IU/177/14/PL

Demolition of original dairy distribution depot and construction of 8 No.

The Old Dairy
Behind 3 & 5 Church Street
Littlehampton

dwellings and ancillary works. Resubmission following LU/298/13. This application may affect the character and appearance of the Littlehampton (East Street) Conservation Area.

SITE PLAN WITH DRAFT LEVELS
 PROPOSED RESIDENTIAL DEVELOPMENT
 THE OLD DAIRY, CHURCH STREET, LITTLEHAMPTON, SUSSEX.
 GRAHAM NICOLLS LIMITED, DESIGN + TECHNOLOGY, TEL/07990 522709

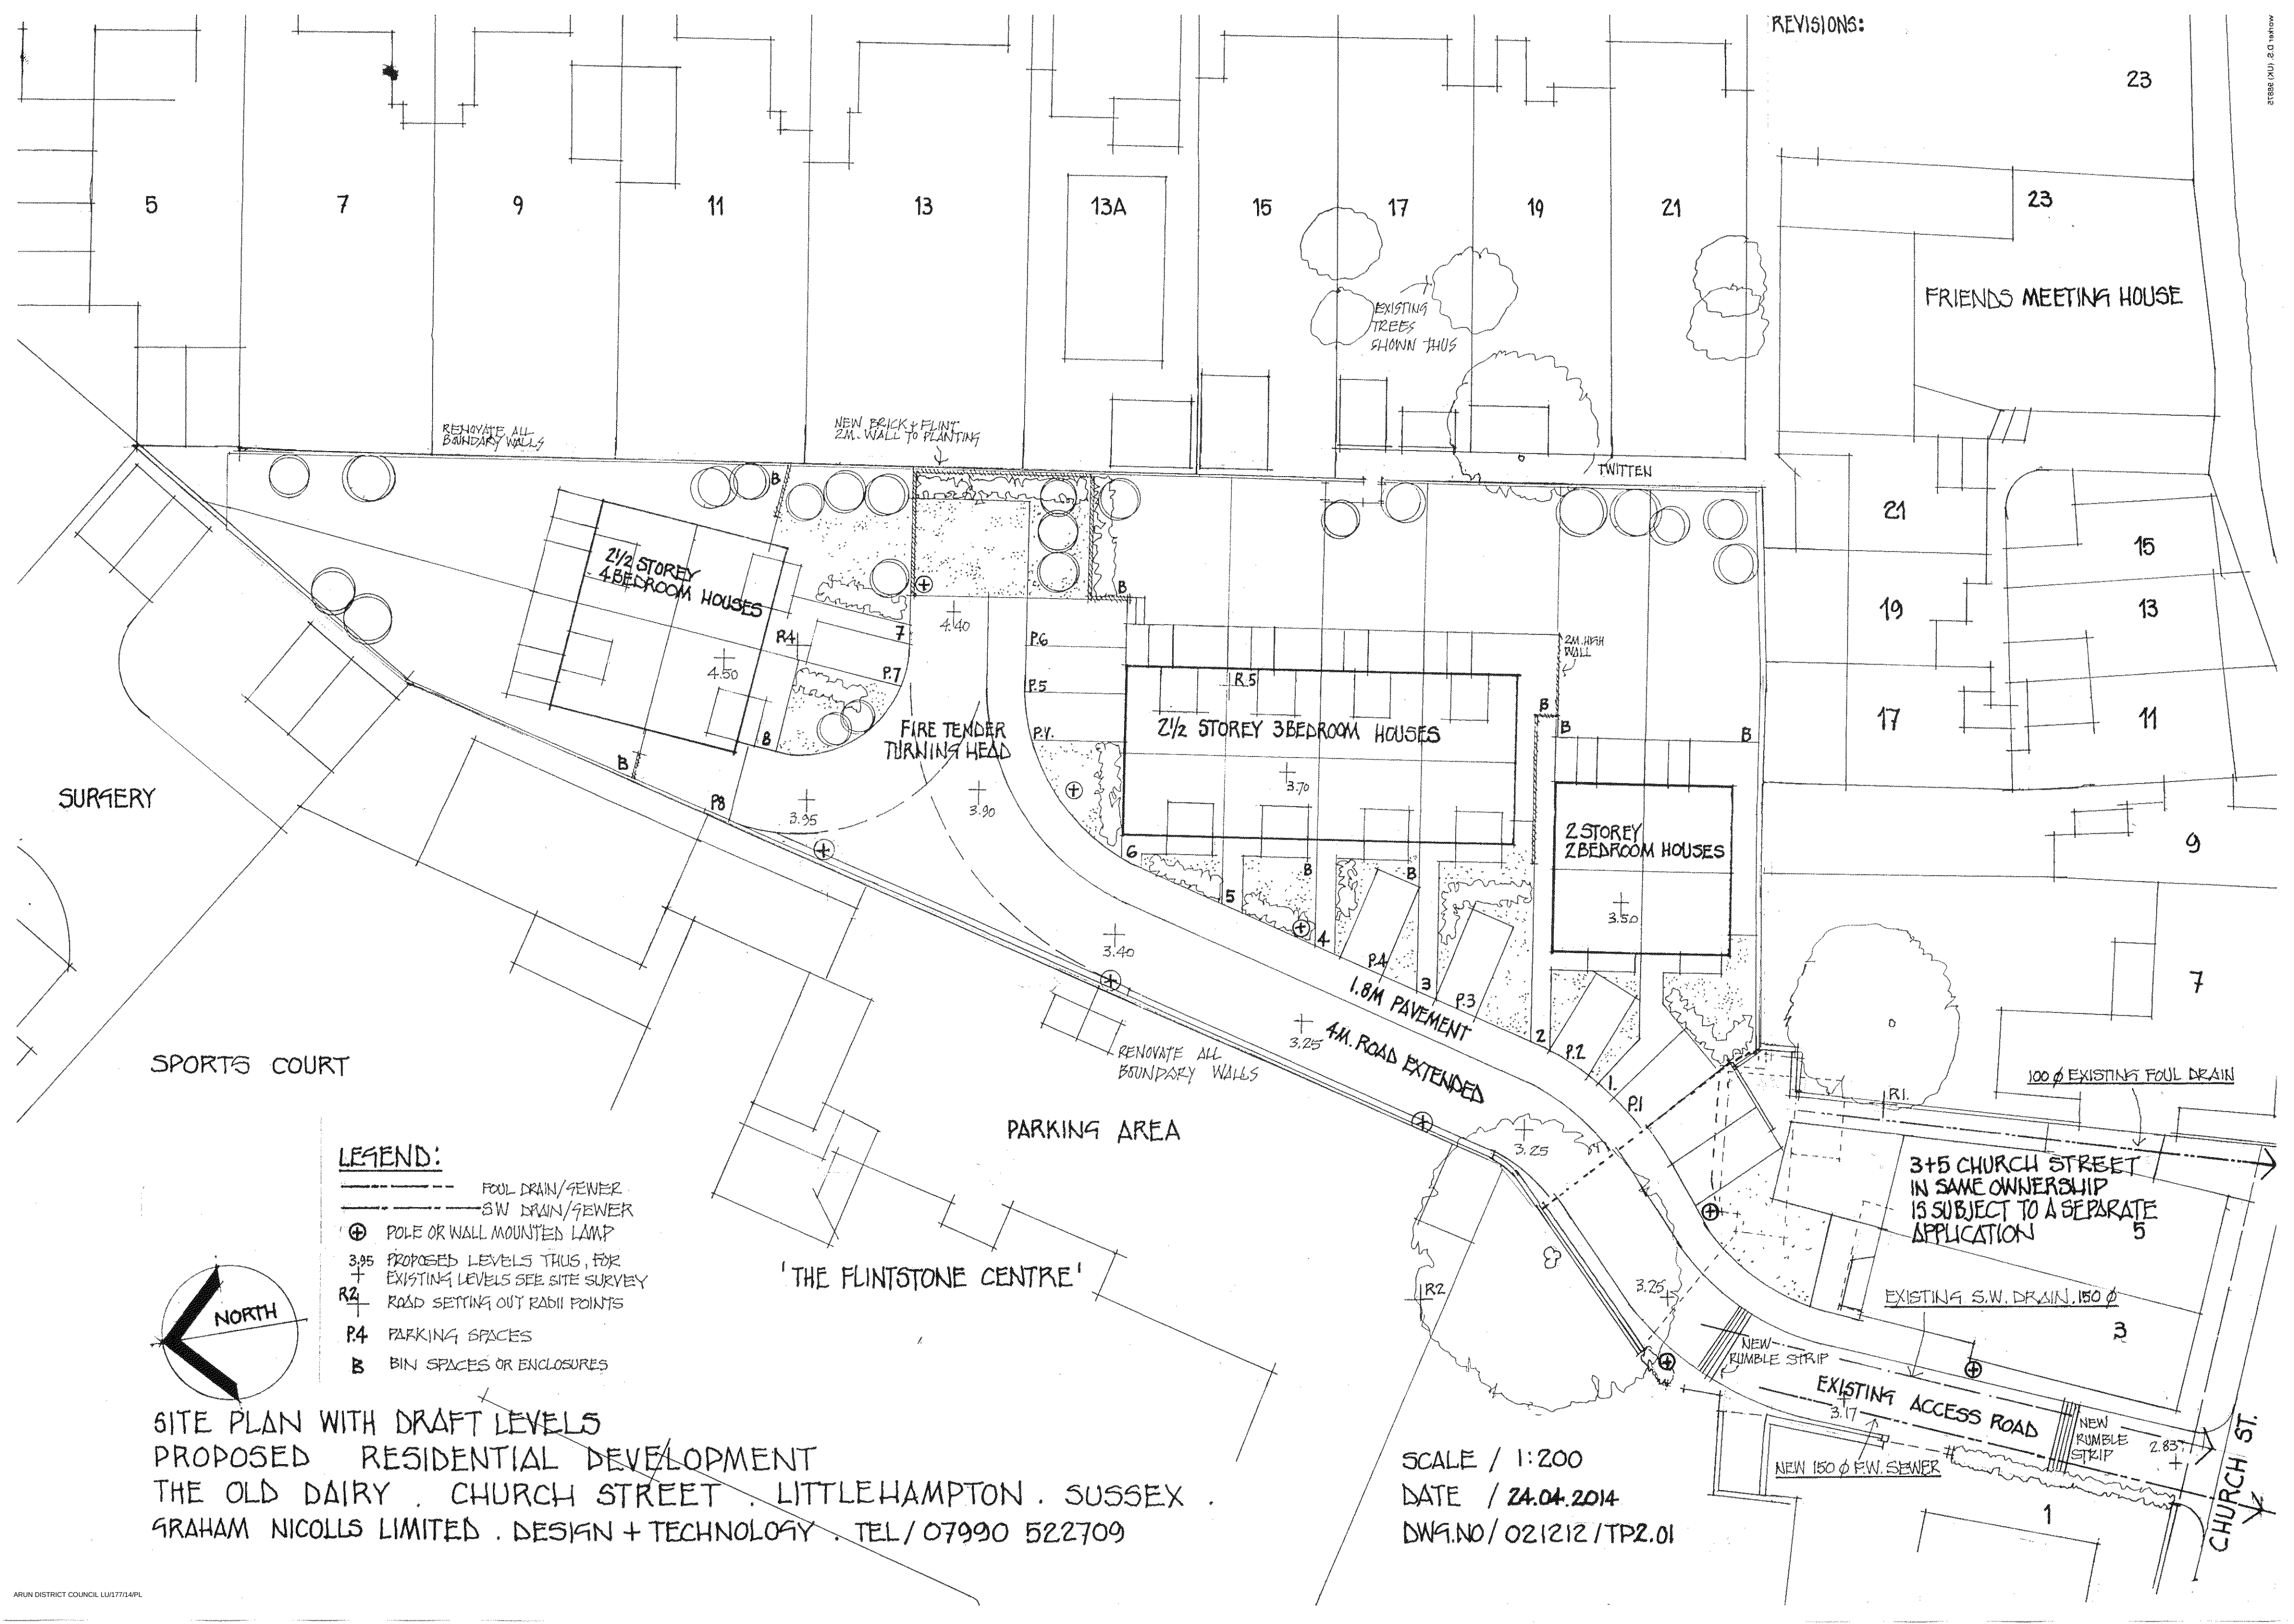
ions: Design unsuitable & out of character
(suggest we look at Floyd's Corner for ideas
(plus room for bins & cars))
